**SURVEYOR'S  
AFFIDAVIT OF CORRECTION**

THAT I AM A LICENSED PROFESSIONAL LAND SURVEYOR IN THE STATE OF COLORADO AND PREPARED THE PLAT OF FOREST LAKES FILING NO. 5, RECORDED ON JULY 13, 2020 UNDER RECEPTION NO. 220714540, IN THE RECORDS OF EL PASO COUNTY, COLORADO,

FOREST LAKES FILING NO. 5
JOB NO. 1175.50
JUNE 24, 2019
SHEET 2 OF 3

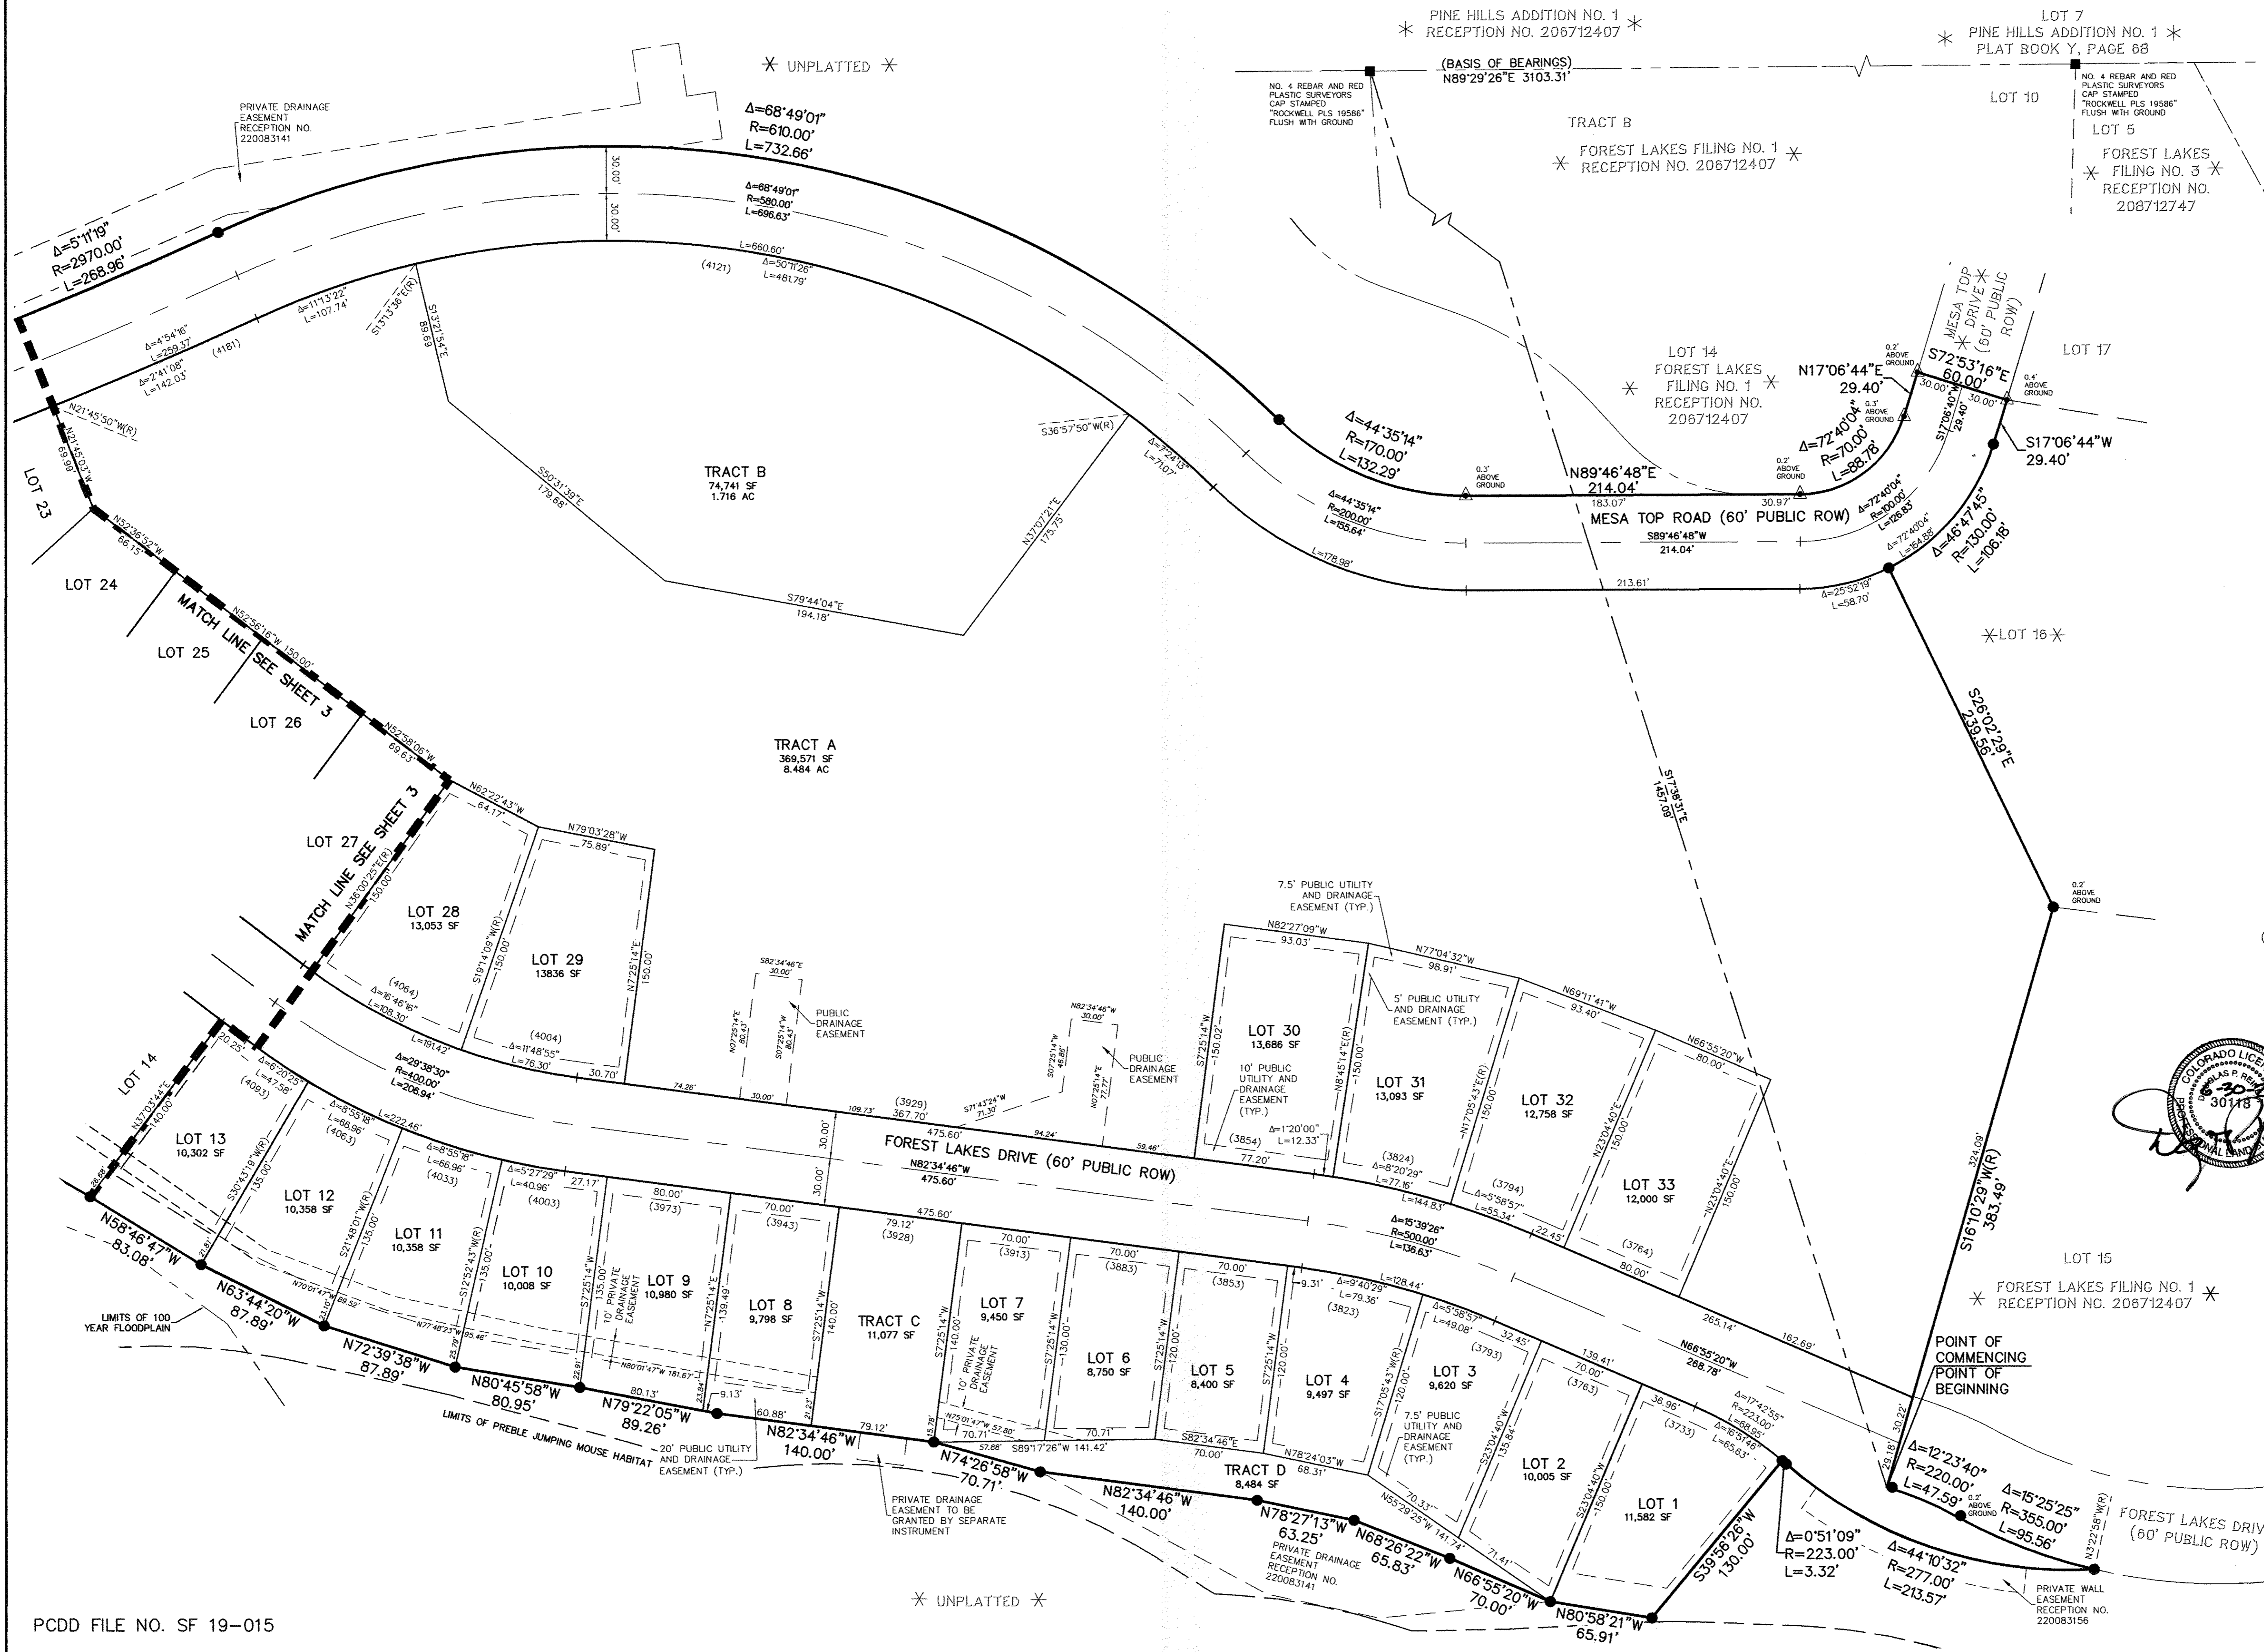
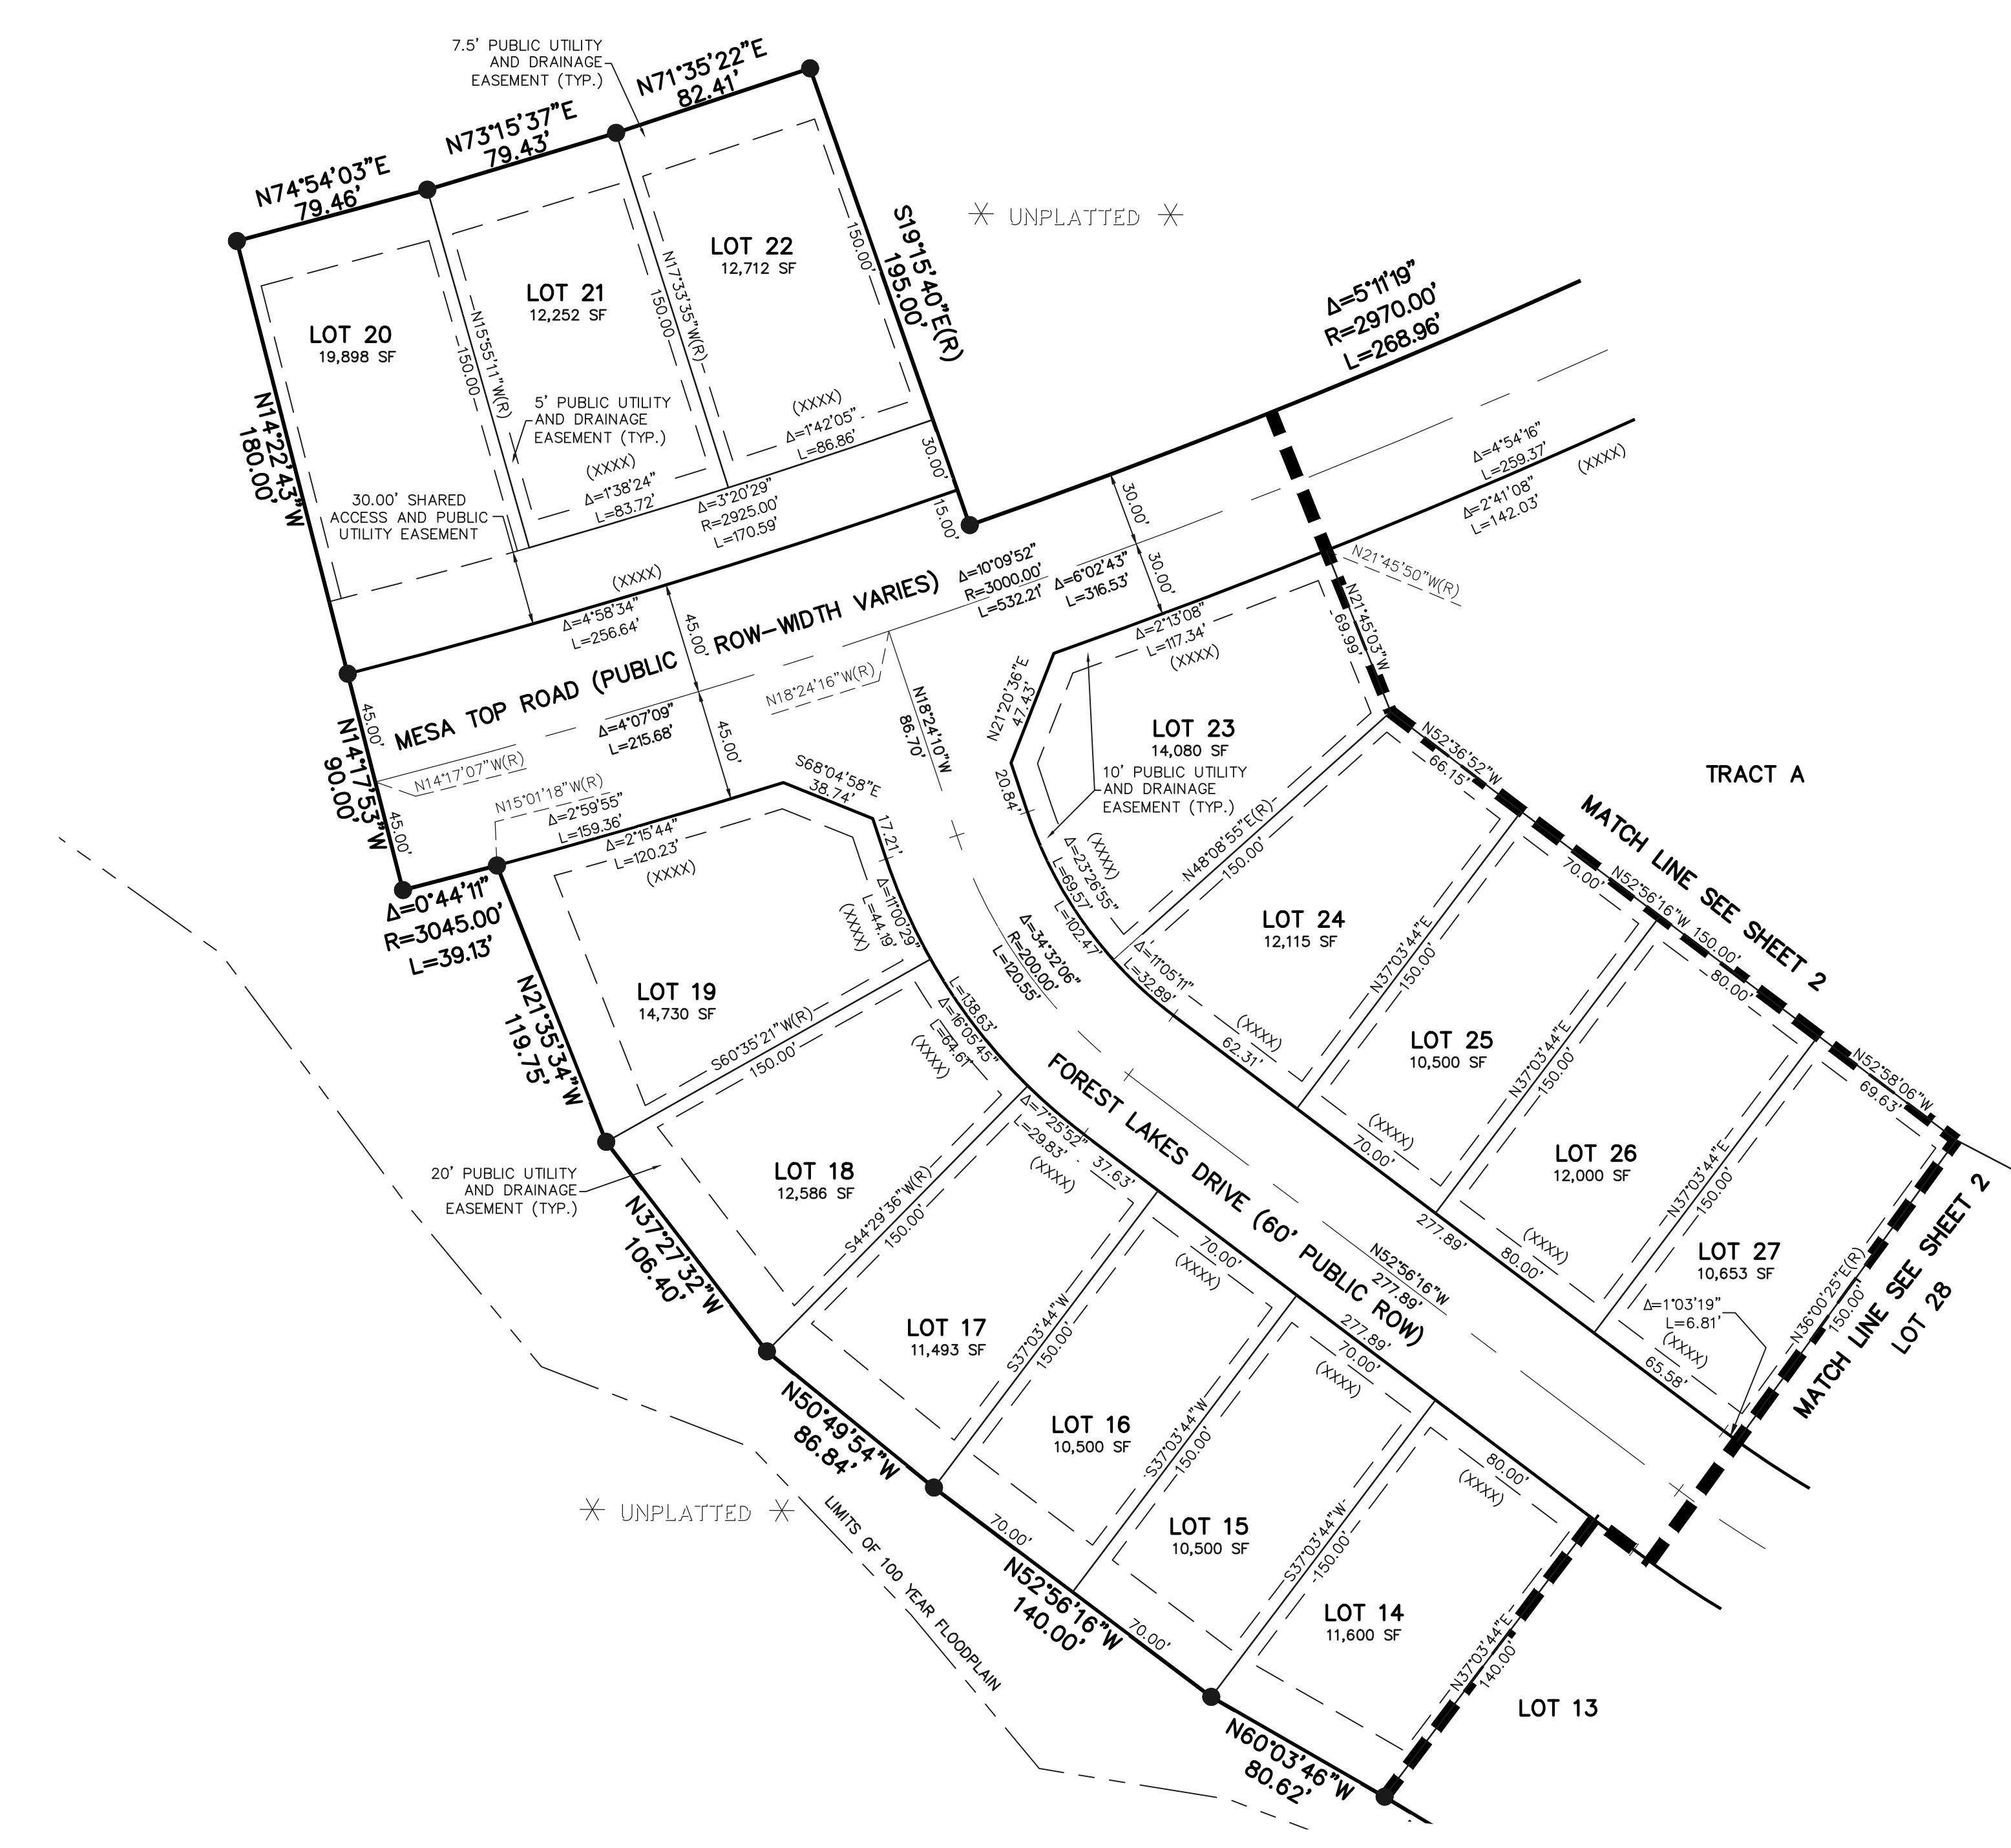
**AS PLATTED**

GRAPHIC SHEETS 2 OF 3 AND 3 OF 3

MESA TOP ROAD

**AS CORRECTED**

GRAPHIC SHEETS 2 OF 3 AND 3 OF 3

MESA TOP DRIVE
